ST ANTHONY OF PADUA SSD -8865 - RESPONSE TO REQUESTS FOR FURTHER INFORMATION

This letter supports the Response to Submissions report (RTS) provided to you on 18 November 2019 in respect of SSDA_8865 for the proposed St Anthony of Padua Catholic School (the Proposal) at 125-165 Tenth Avenue and 140-170 Eleventh Avenue, Austral (the site).

This letter has been prepared on behalf of SCS in response to NSW Department of Planning, Industry and Environment's (DPIE) request for additional information of 9 December 2019 and further request of 29 January 2020.

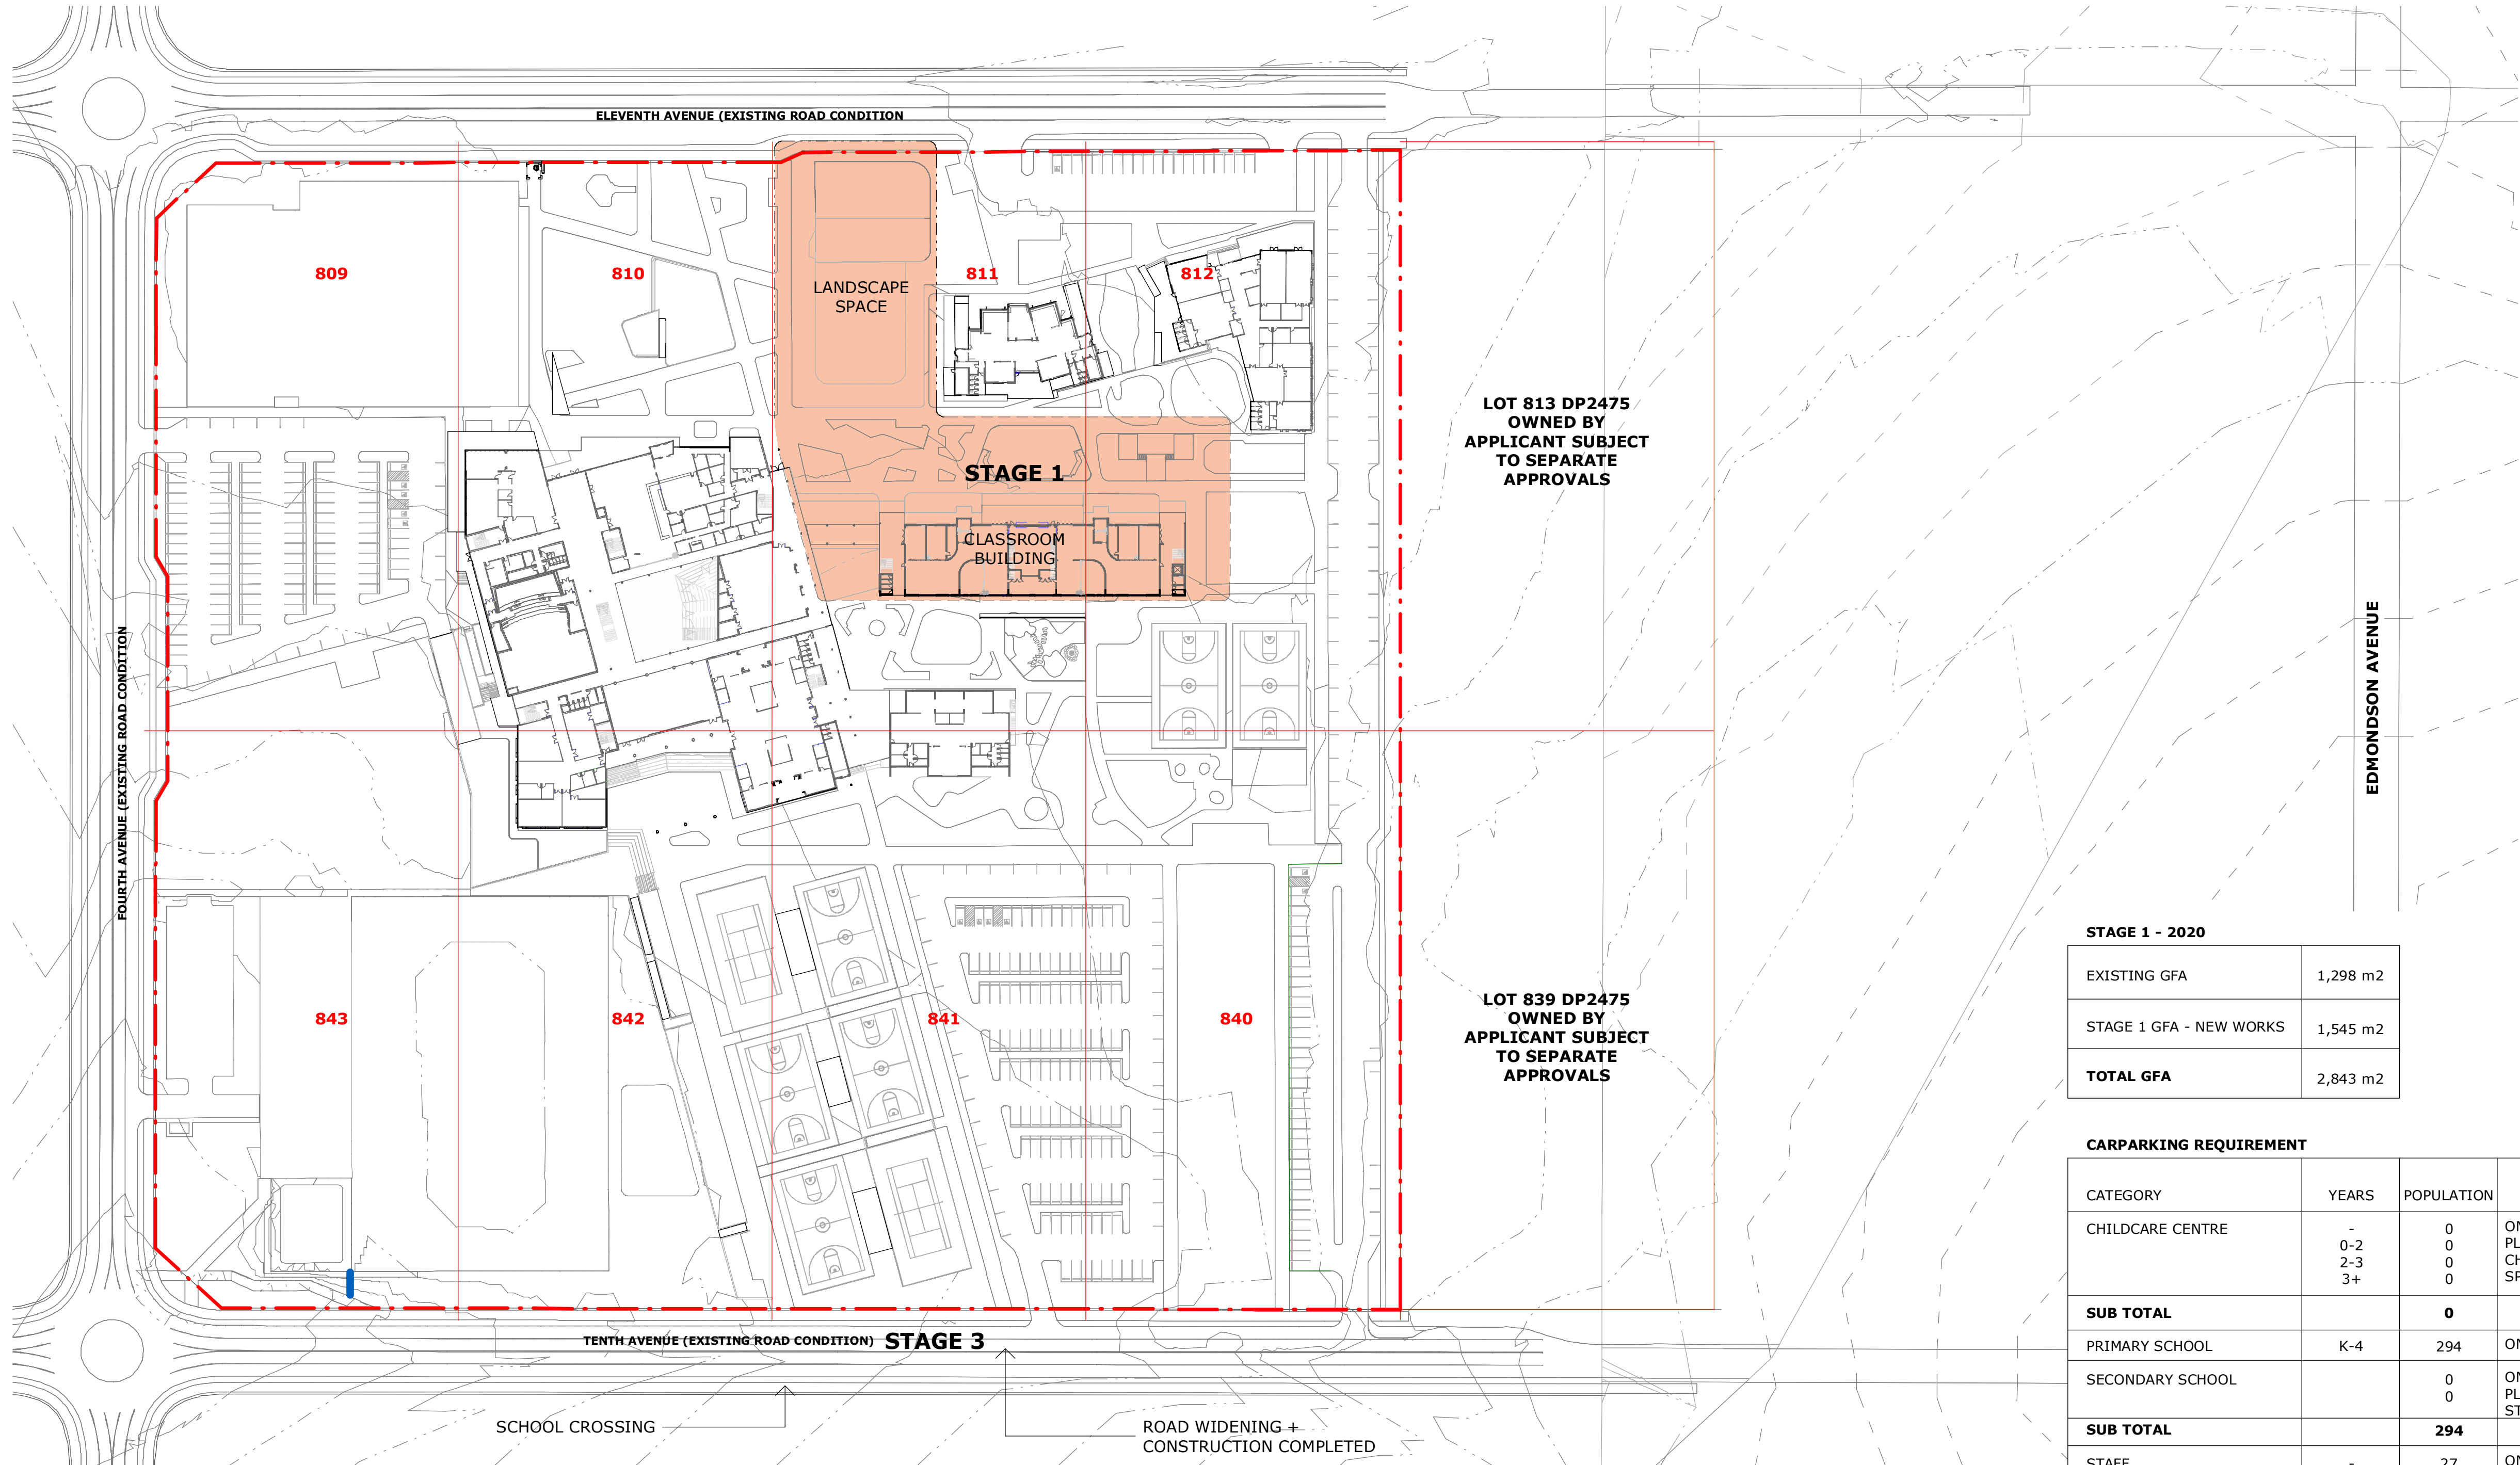
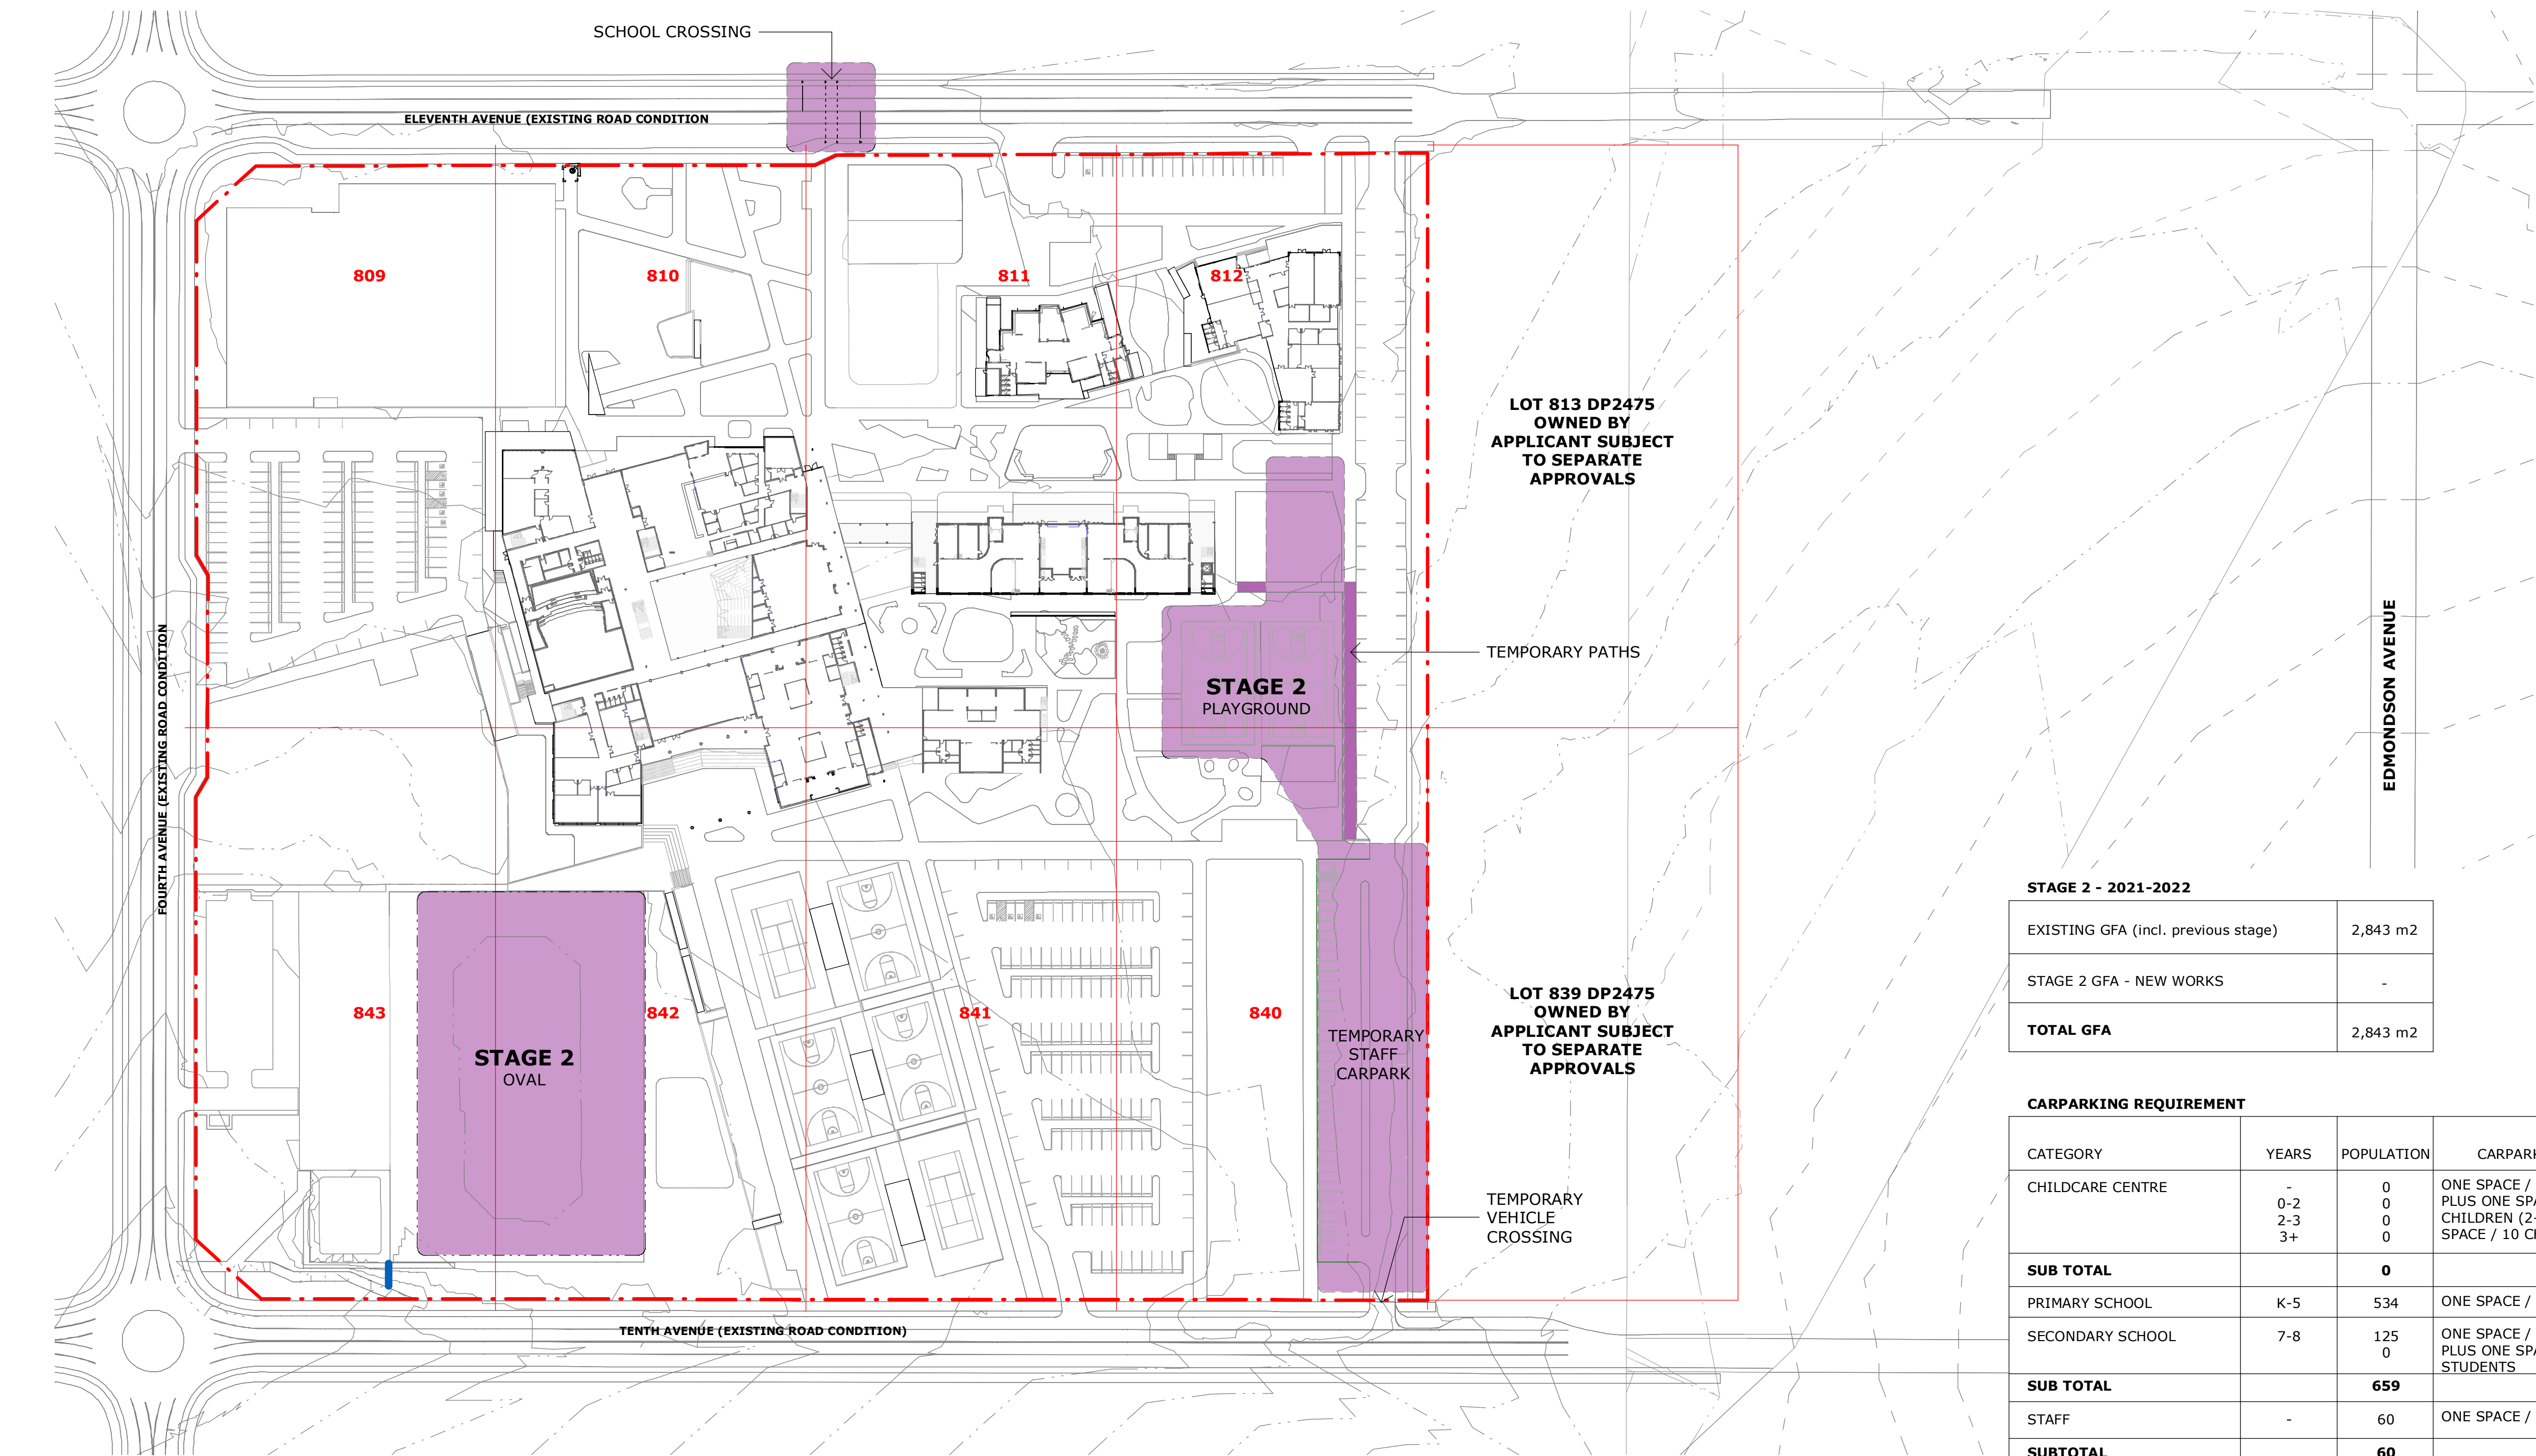
<p>4.4 In addition to student and staff numbers for each stage, the following information are also required for each construction stage:</p> <ul style="list-style-type: none"> the number of drop-off and pick-up spaces, bike parking spaces for each stage and whether the numbers are adequate to cater for the number of 	<p>Amended staging plans have been prepared which provide this information- refer DA052-DA059.</p>	<p>Attachment A- Architectural Plans – refer DA052-DA059 inclusive.</p>

Matter	Response	Refer to
<p>students.</p> <ul style="list-style-type: none"> the gross-floor area for each construction stage. The correct number of car parking and drop-off and pick-up spaces for construction Stage 4 noting that the existing information is incorrect (177 car spaces) as it does not include the proposed 22 drop-off and pick-up spaces. 	<p>Overall site GFA plans have been provided at DA131_R10 and DA132_R10. GFA per stage has also been quantified on the amended staging drawings, refer DA052-DA059.</p> <p>The number of car spaces inclusive of drop/off pick up spaces for Stage 4 is 227 and this has been corrected on DA055_R7.</p>	<p>Attachment A-Architectural Plans – refer DA131_R10 and DA132_R10.</p> <p>Attachment A-Architectural Plans – refer DA055_R7.</p>
5 Road widening		
<p>5.1 The RtS indicates that the proposed development includes road widening of Tenth Avenue, Eleventh Avenue and Fourth Avenue. While Eleventh Avenue is proposed to be fully widened, the civil plans show that Tenth Avenue and Fourth Avenue would only be widened for half of the width. The RtS does not clarify whether the remaining section would be widened as part of this proposal or at a later date. It also does not include reasons for not proposing the road widening for the full width of the road.</p>	<p>The proposal is for the widening of Tenth Avenue and Fourth Avenue along the site frontage. The proponent does not intend to widen the roads beyond the site frontage at any point in the future.</p> <p>The proposal also does not propose to widen the southern side of Tenth Avenue or the western side of Fourth Avenue at this time or at any point in the future. It is unreasonable for the proponent to be made to bear the cost of widening the roads beyond the boundary of the school site or for the cost of widening both sides of Tenth and Fourth Avenue.</p> <p>The proposal to widen the road as shown in the accompanying civil plans is satisfactory to accommodate 4 lanes of traffic</p>
